Aquind Interconnector Project
Application for a Development Consent Order

Ref: EN020022

Response to Deadline Three

3 November 2020

Appendix 2 – Converter Station Access Drawing

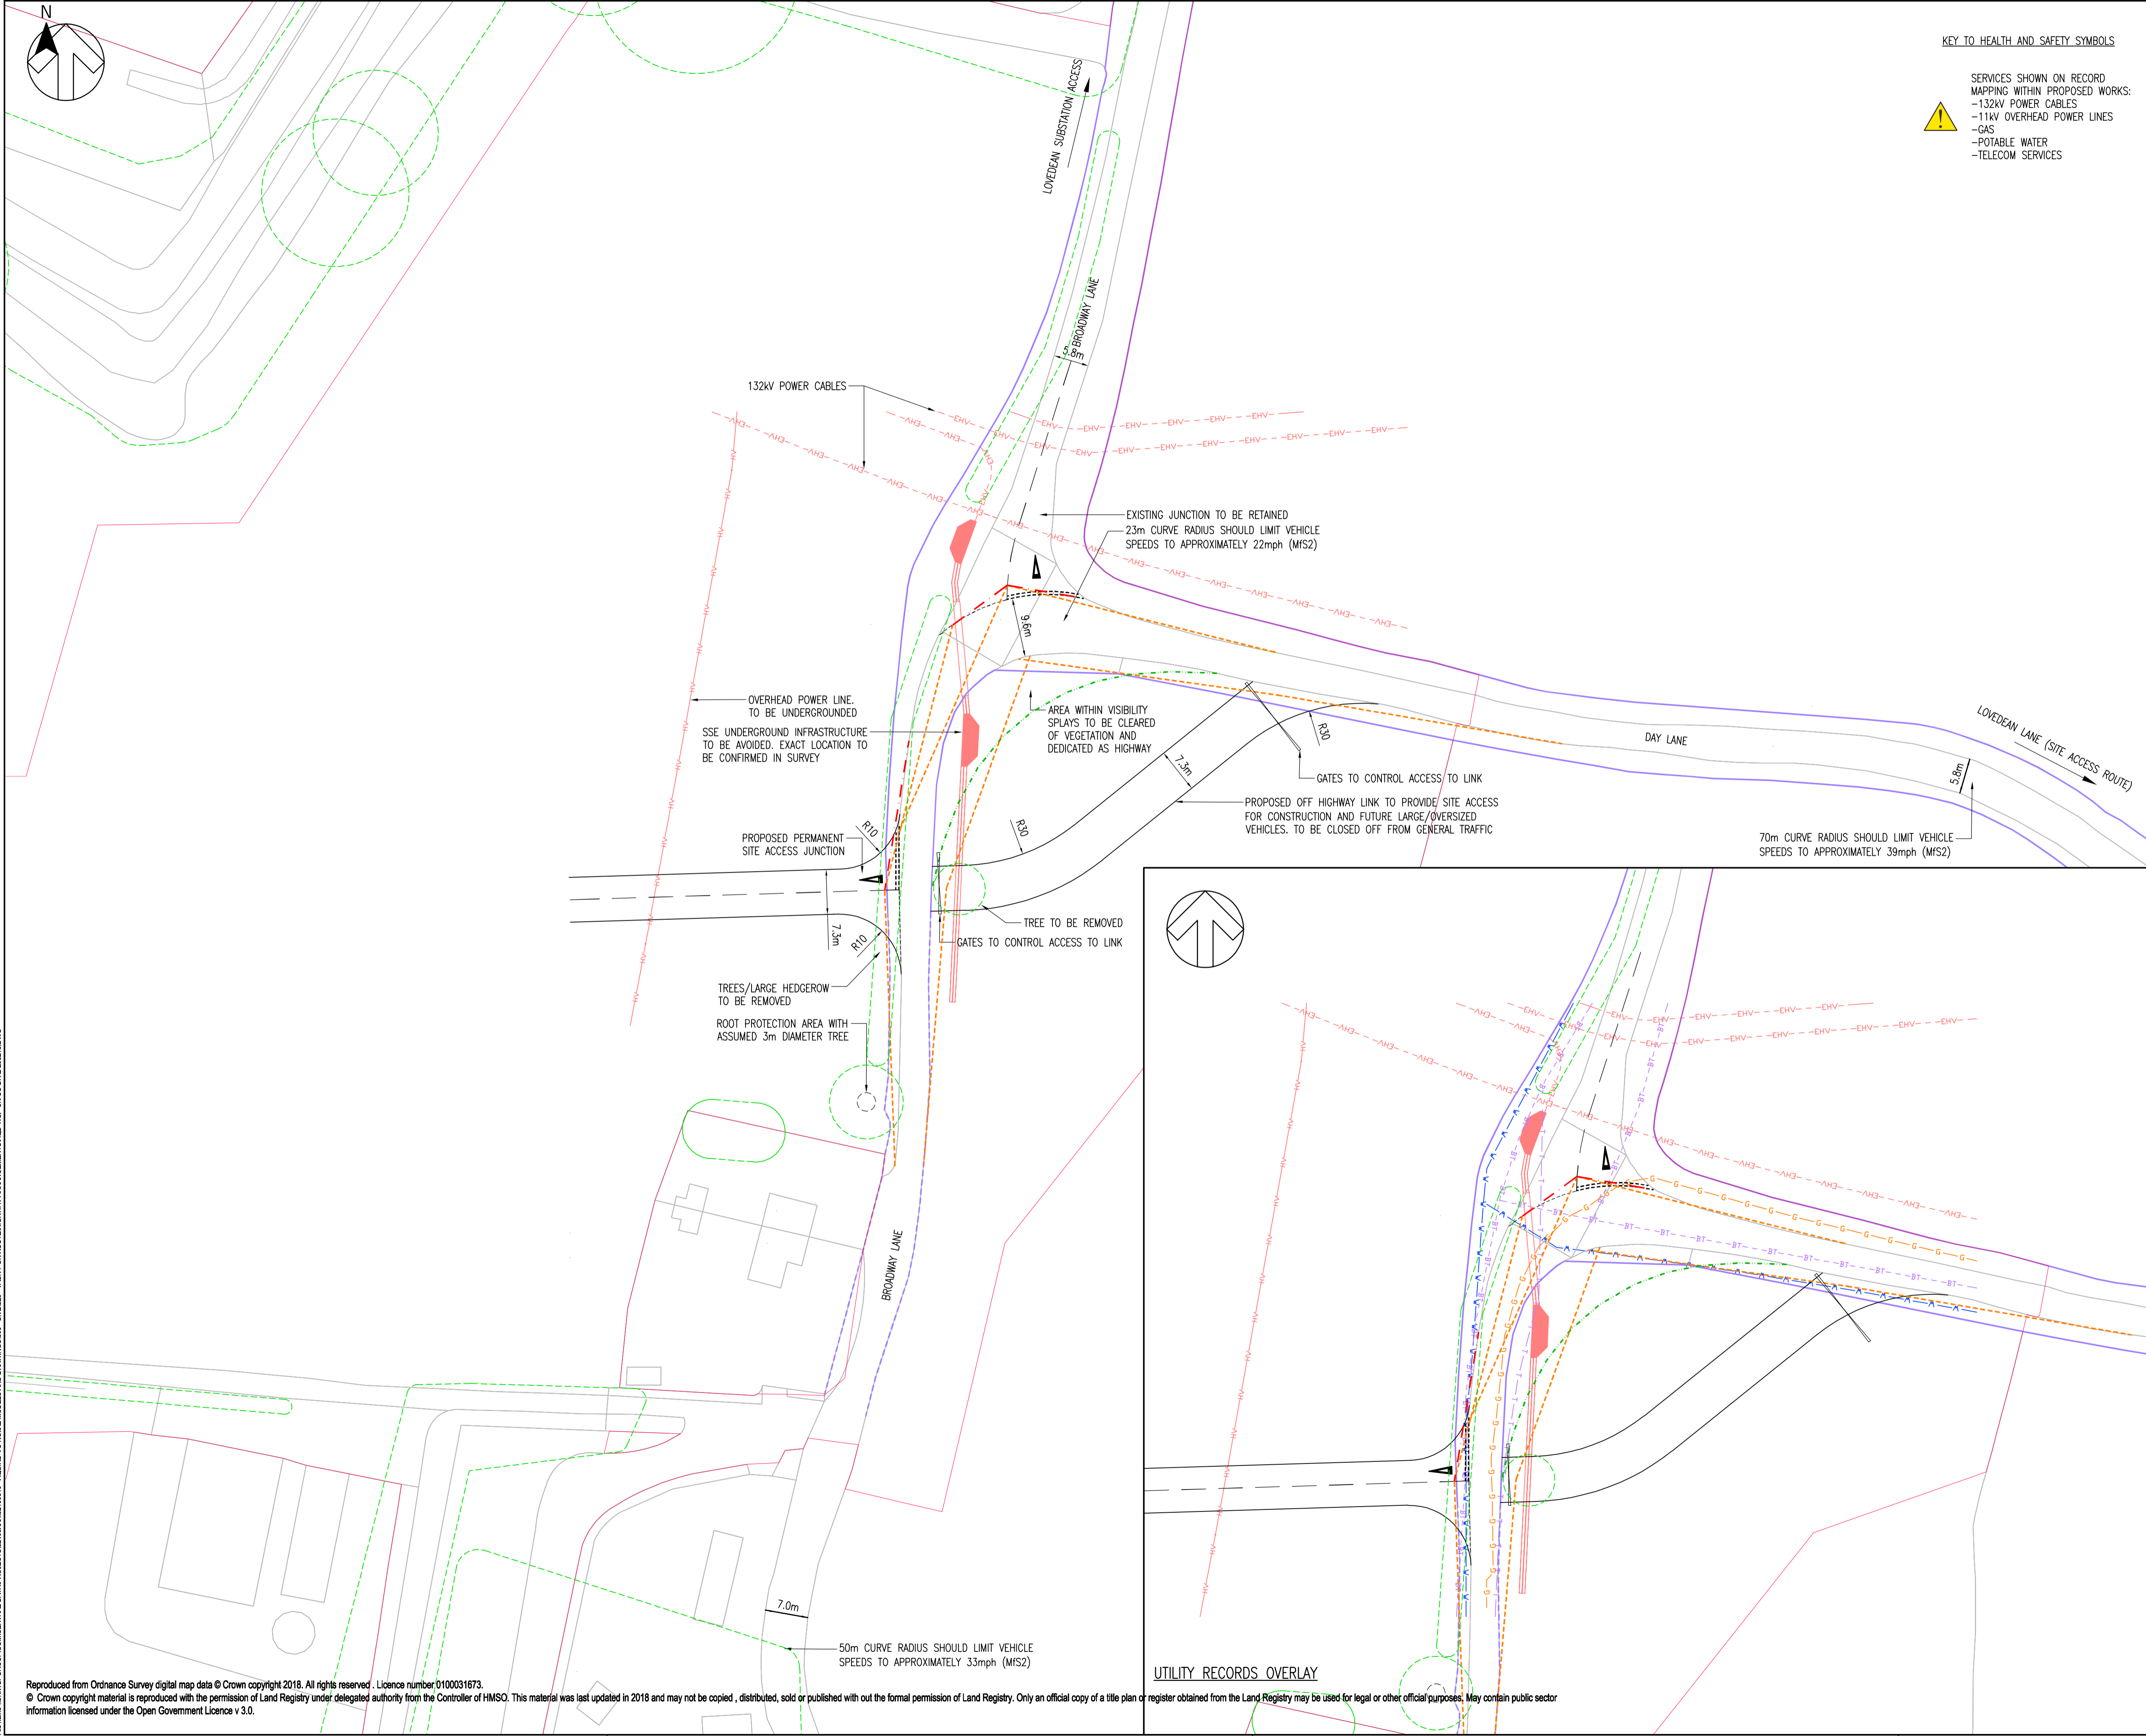
4.8 EHDC welcomes discussions on the proposed entranceway at Broadway Lane / Day Lane.

4.9 The engineering requirements for the access in the location proposed for construction purposes are noted eg to accommodate abnormal loads and the needs to avoid impacting on the belt of trees to the north. However, it is the permanent retention of the track in this location that is a concern and it considers that a route that better relates to existing landscape features and which avoids the protected trees could be used given the low level of operational traffic once operational.
